Project Name: **Papi & Romano Builders Shop**
Project ID: #2014-211
Address: 828 Riverside Street CBL: 325 B008 001
Applicant: Rick Romano
Planner: Jean Fraser

On December 23rd, 2014 the Planning Authority approved with conditions a Level II site plan for the demolition of a garage and construction of a new 4534 sq ft woodworking and builders shop at 828 Riverside Street. The decision is based upon the application, documents and plans as submitted by Rick Romano and prepared by Whipple Callender Architects and Pinkham & Greer Civil Engineers as listed at the end of this letter. The proposal was reviewed for conformance with the standards of Portland's site plan ordinance.

Public Services Review Comments

Re: 828 Riverside Street – Proposed Woodworking Building – Rick Romano

2 SITE PLAN
SCALE: 1" = 10'

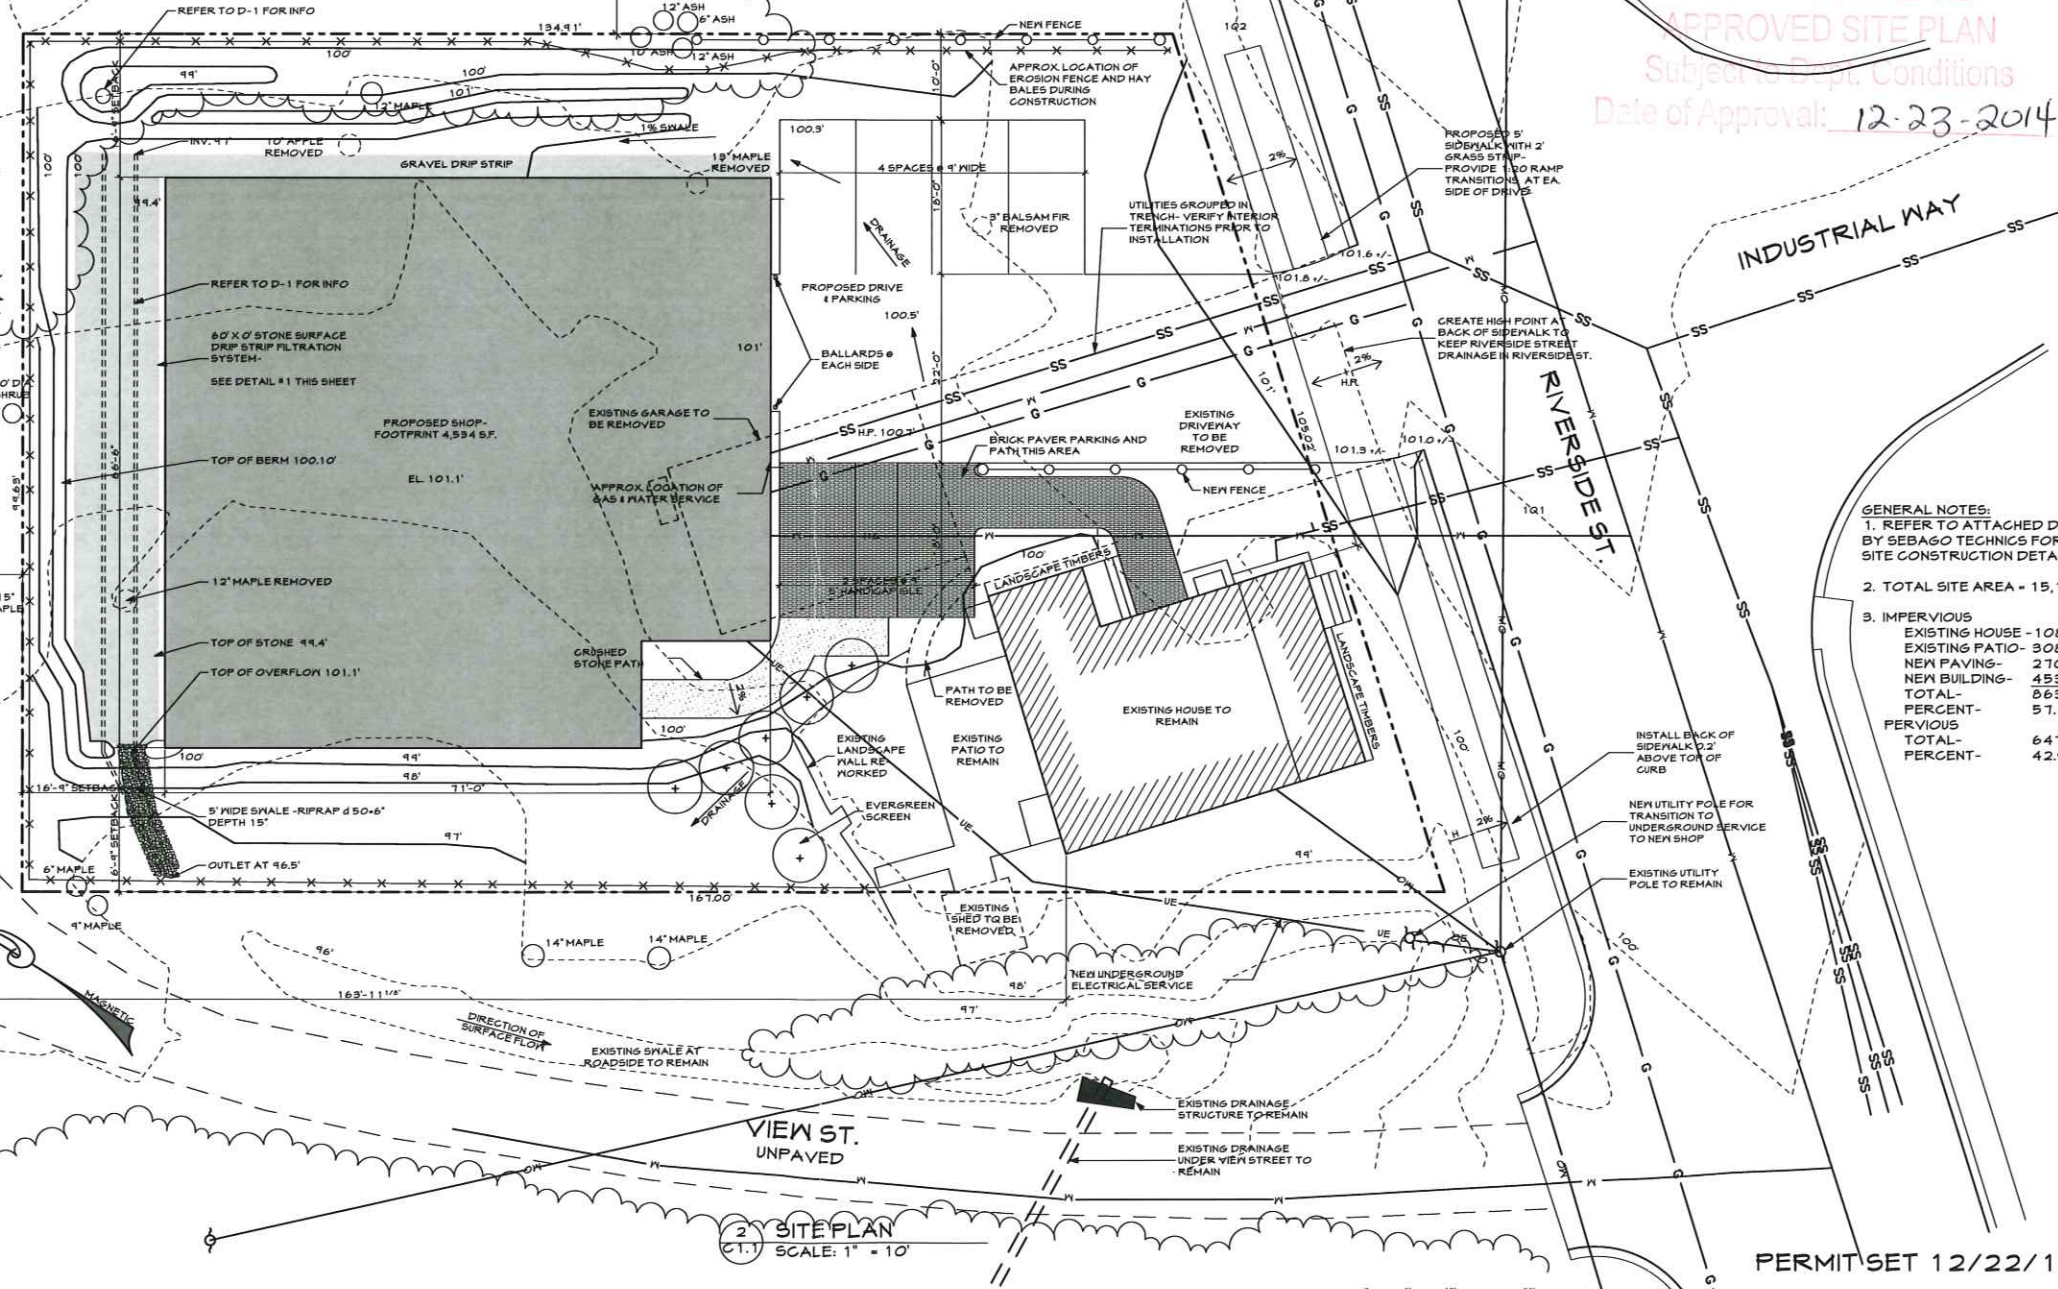
- Applicant current shows an approximate 10’ x 10’ shed within the View Street R-O-W. Applicant shall indicate that this shed will be moved onto the applicant’s property within the required 10’ setback line. Applicant has indicated they will move the shed.

- It would be beneficial to show a shaded area indicating that all three proposed utility trenches in the road will be repaired as one repair.
- Although a manhole is not shown where the sewer connection is proposed, it appears the applicant intends to connect the sewer lateral to a manhole. This practice is currently not allowed per the City’s Technical Manual. Our records indicate the sewer in the street is 8” PVC. We are requesting show the applicant’s sewer lateral connecting to the 8” PVC.

The service layout for the new building is not acceptable. Service taps and service lines need to be perpendicular to the main. We would suggest one service tap at the main in the location of the other utilities. You can then split into the domestic and fire just before the street line with service valves on both lines at the street line. We would be happy to work with you to come up with an acceptable service line layout.

6. That the Site Plan shall be revised, for review and approval prior to the issuance of a building permit, to address the detailed comments of the Department of Public Services dated December 19, 2014 and the detailed comments of the PWD letter dated December 18, 2014 (last para).
